**ADC Planning Consultation
Conservation/Design Officer Response**

Application Number	AW/55/18/HH
Address	3 The Orchard Aldwick PO21 4HX
Description	Rear and side, single and two storey extension incorporating rear balcony. This application affects the Character & Appearance of the Aldwick Bay Conservation Area
Case Officer	<u>Mr S Davis</u>
Date	7 TH March 2018

SIDE ELEVATION

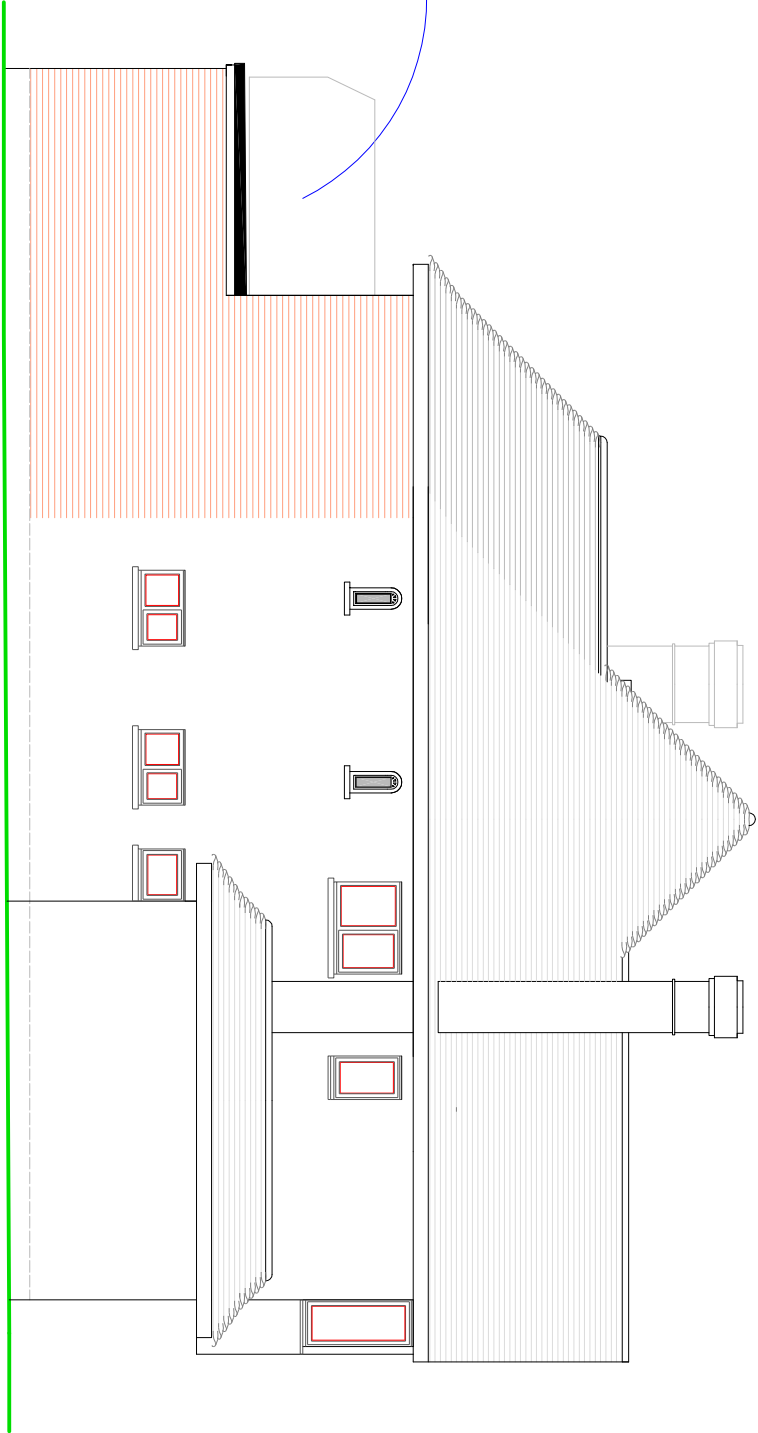
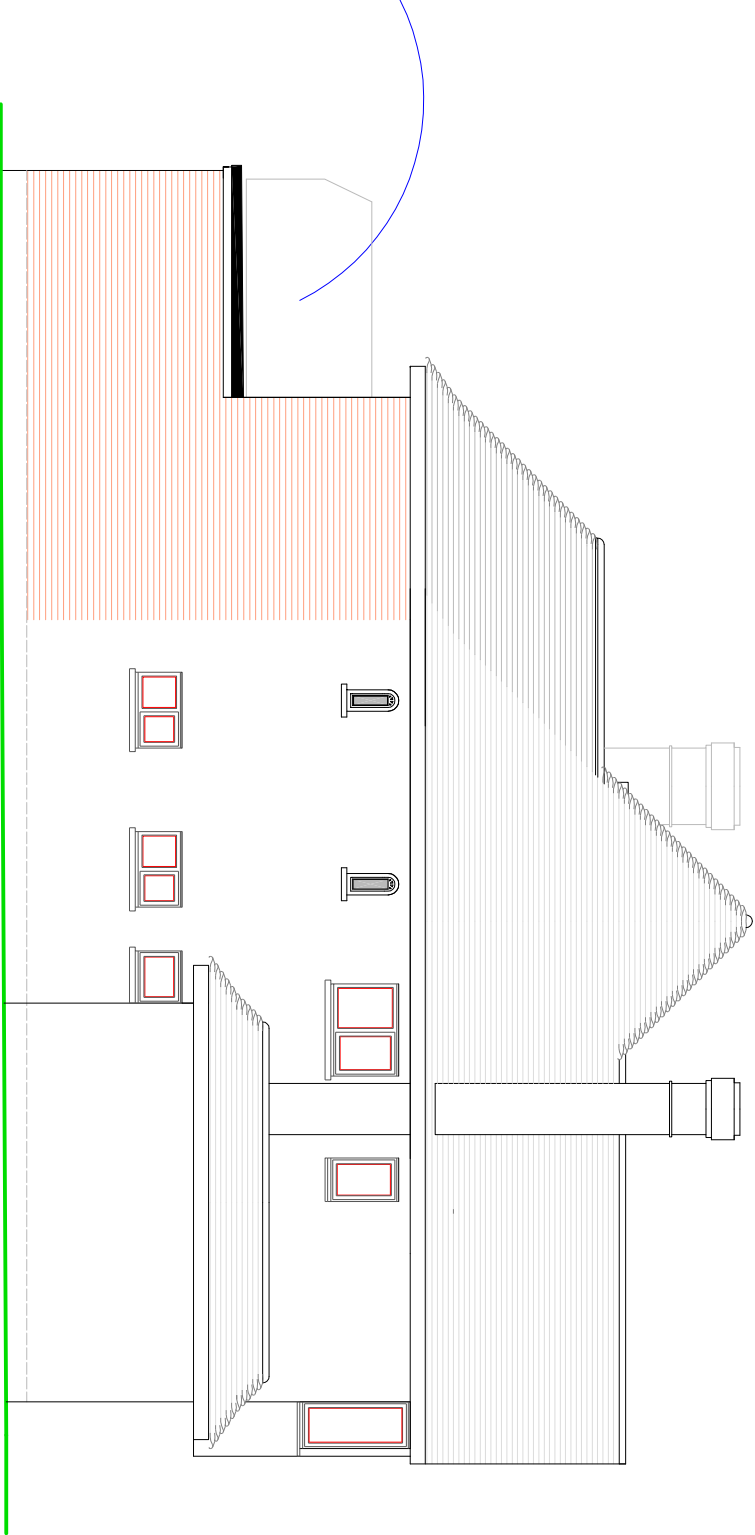
Although much of the proposed extension would not be visible from the public realm, the proposed glazed balcony on 'Side Elevation' would be visible form the street scene. It is considered that this element would represent an alien intrusion, and is recommended that this element be revised to a non-reflective surface, that would retain the visual permeability of the site.
